Harnett County Government Complex  
307 W. Cornelius Harnett Boulevard  
Lillington, NC 27546

Champs Fresh Food  
8909 US-401  
Fuquay-Varina, NC 27526

Re: BCOM2311-0004

The plans and specifications for the above referenced facility have been reviewed and approved. The revised site plan received on June 25<sup>th</sup> with the addition of the two door freezer, along with additional changes from the original site plan submitted to Central Permitting, is approved. This revised site plan must be submitted to Central Permitting, reviewed and approved by Building and Fire.

PROPOSED LAYOUT

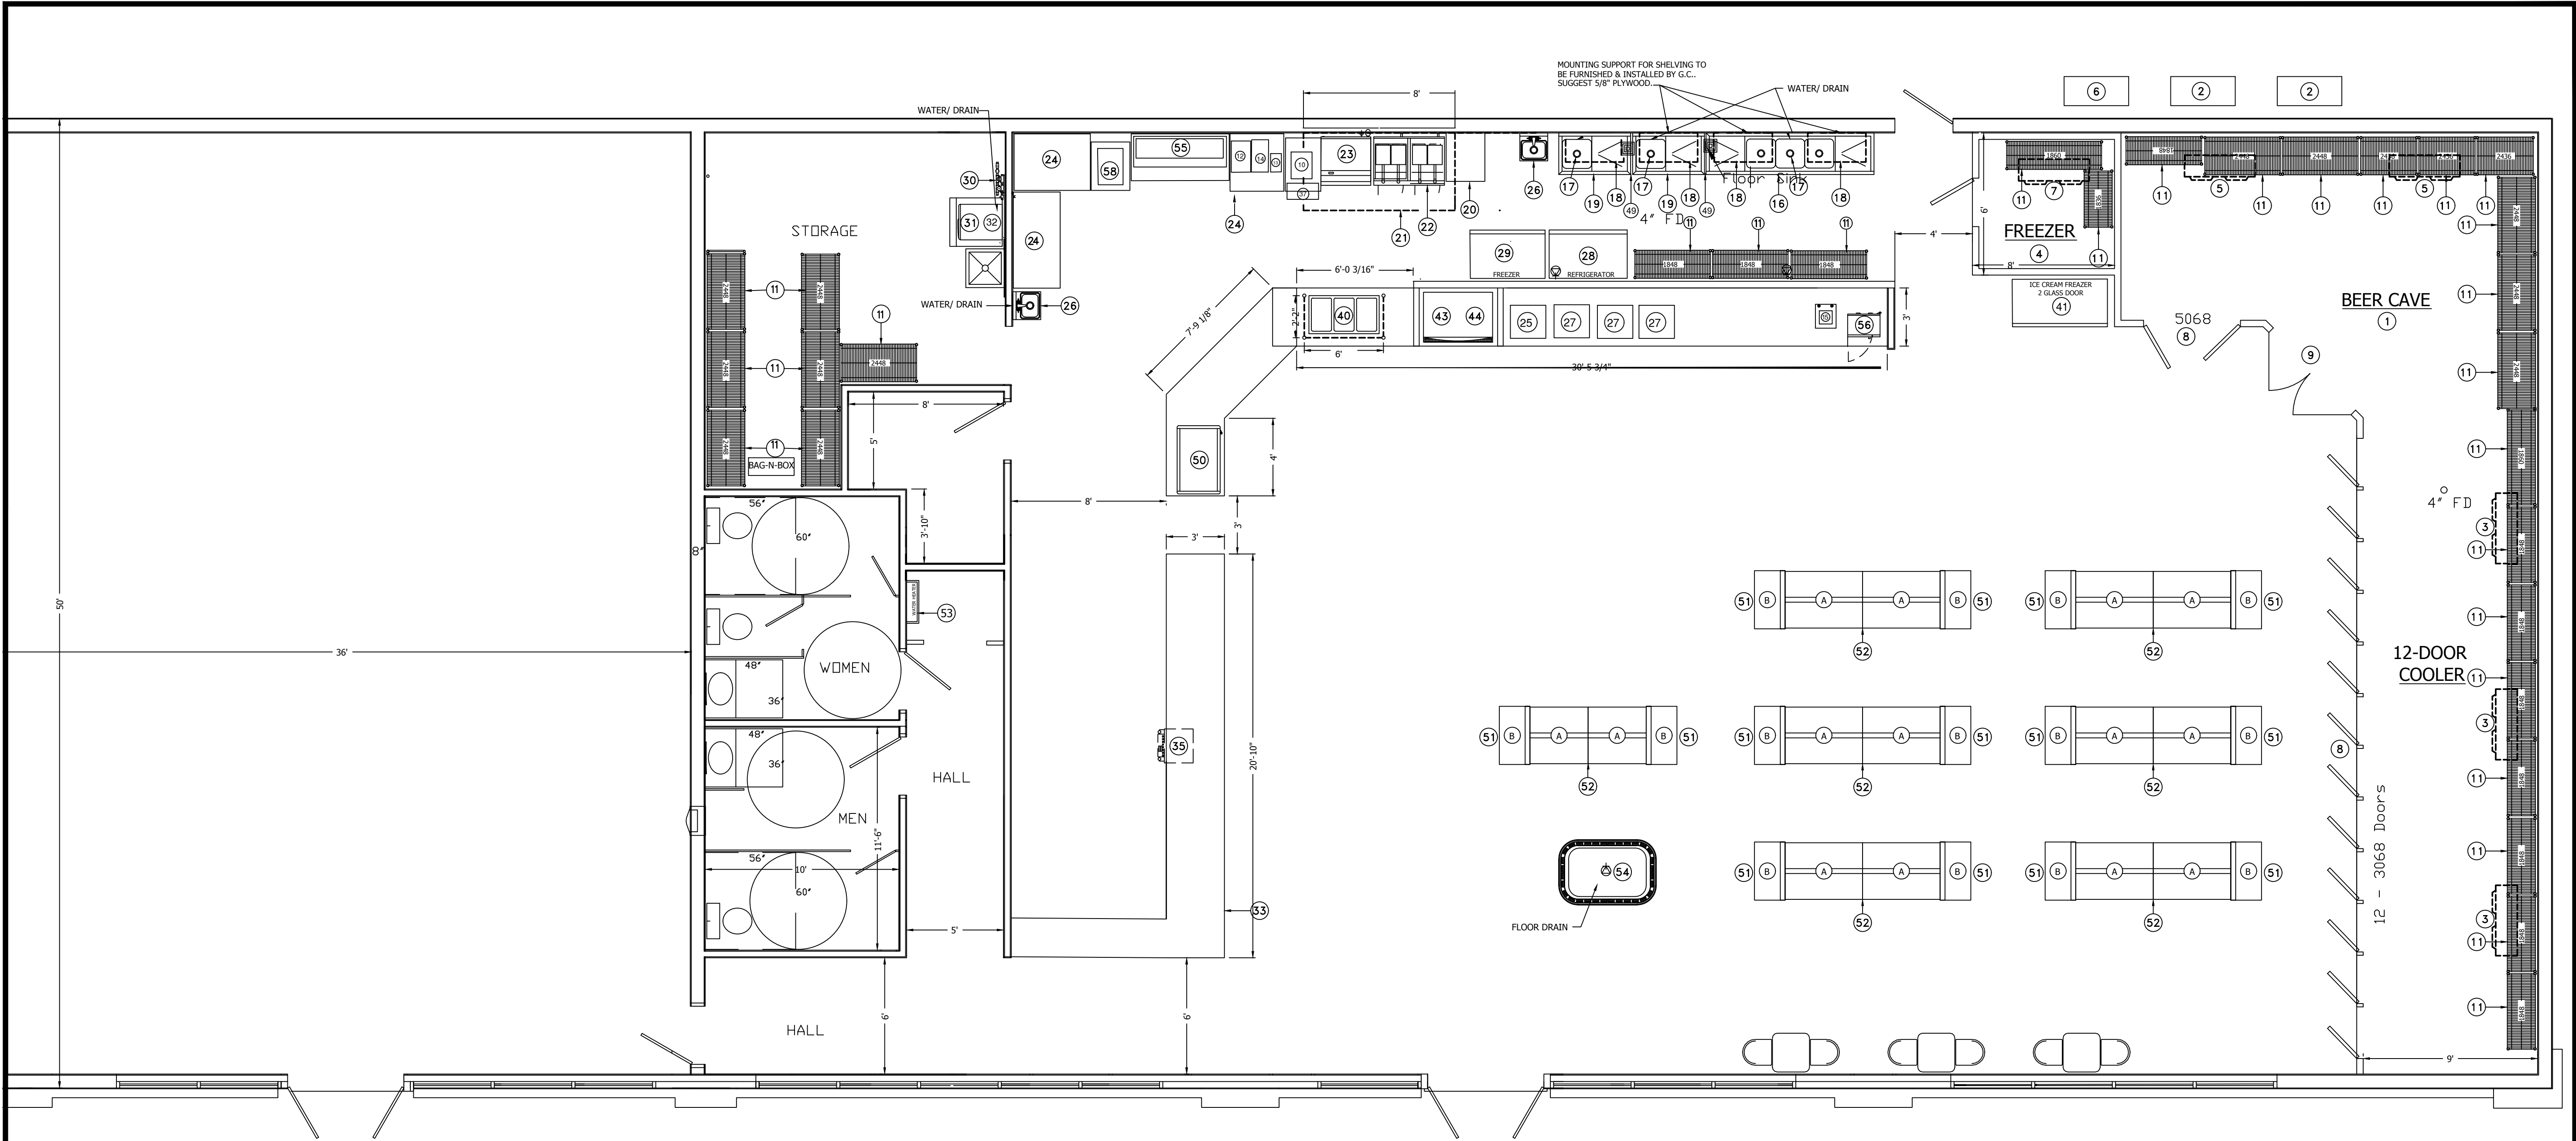
1-All meat must arrive ready to cook. The one compartment food prep sink shall be designated for the preparation of vegetables only.

2-The half wall located between the food prep sink and dishsink is not necessary. A splashguard will suffice as a barrier to separate the two areas.

3-Area on plan labeled STORAGE must have adequate storage space dedicated for the food, single service items, and all other supplies for the food service operation.
